Permit Number: 031195

has permission to Install 3 Antennas & Base Station Equipment for 4G LTE Network

SUBJECT: Portland Maine Wireless Communications Projects

Promenade East

PROMENADE EAST
SITE NUMBER: 853332
ADDRESS: 34.0 EASTERN PROMENADE
DRAWING TITLE: SITE PLAN

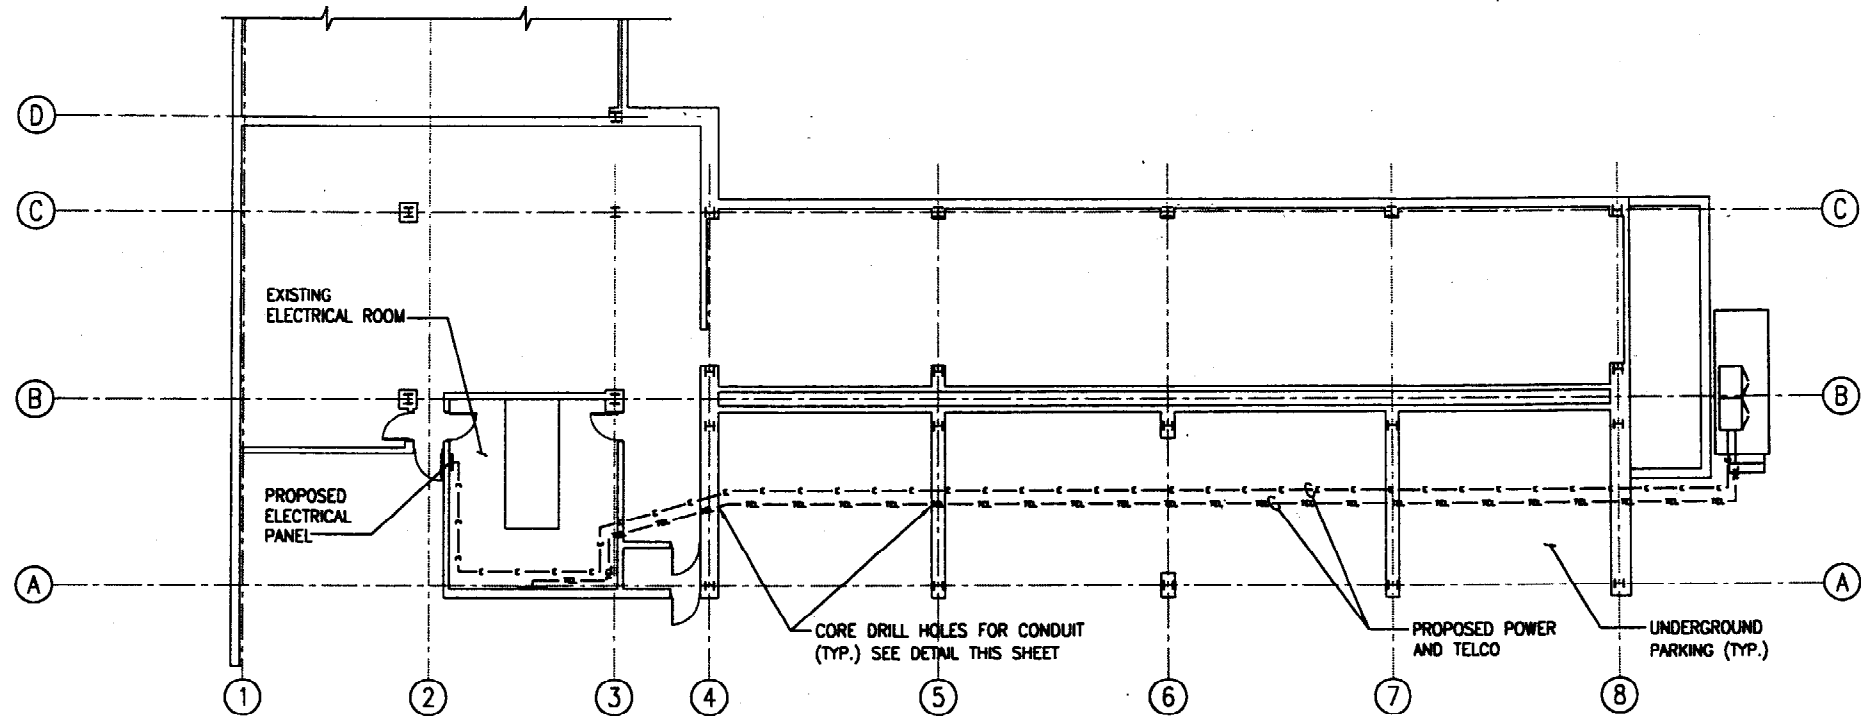
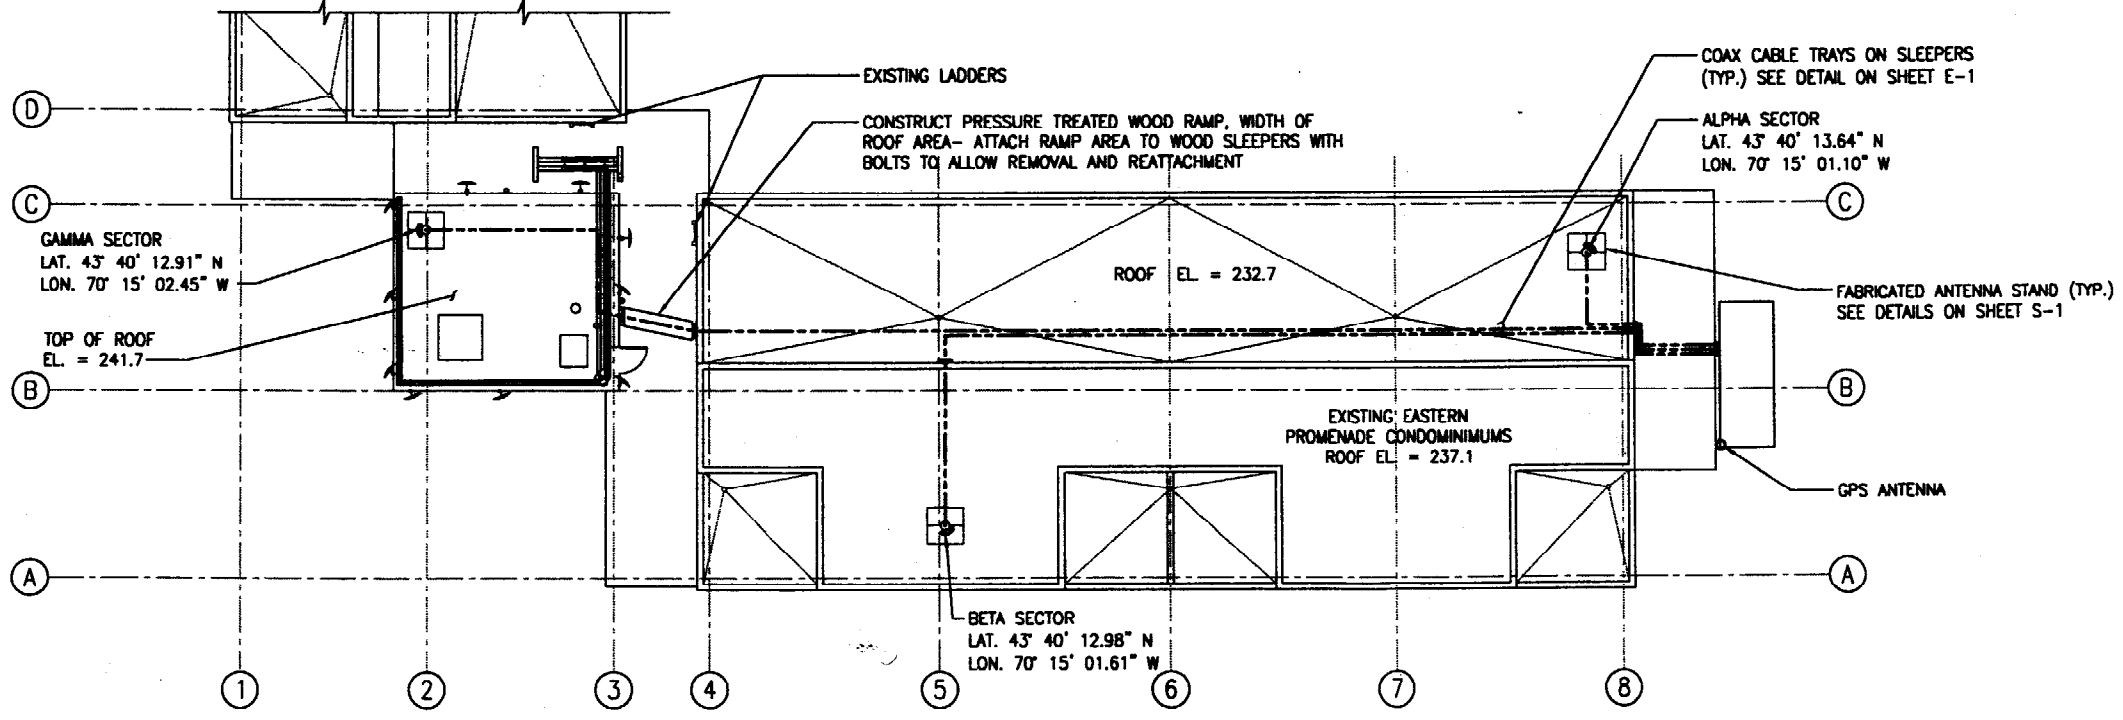
10/14/2003-mjn: Guard design? Roof loads, Special inspections

1. The answer to the question that you raised about the railing configuration around the platform as shown on our drawings is Use group U. This allows the railing to be as shown. The whole equipment platform is enclosed in a locked wood fence compound.
2. The analysis of the existing roof for capacity is shown in the calculation package as submitted on pages 2 thru 5.
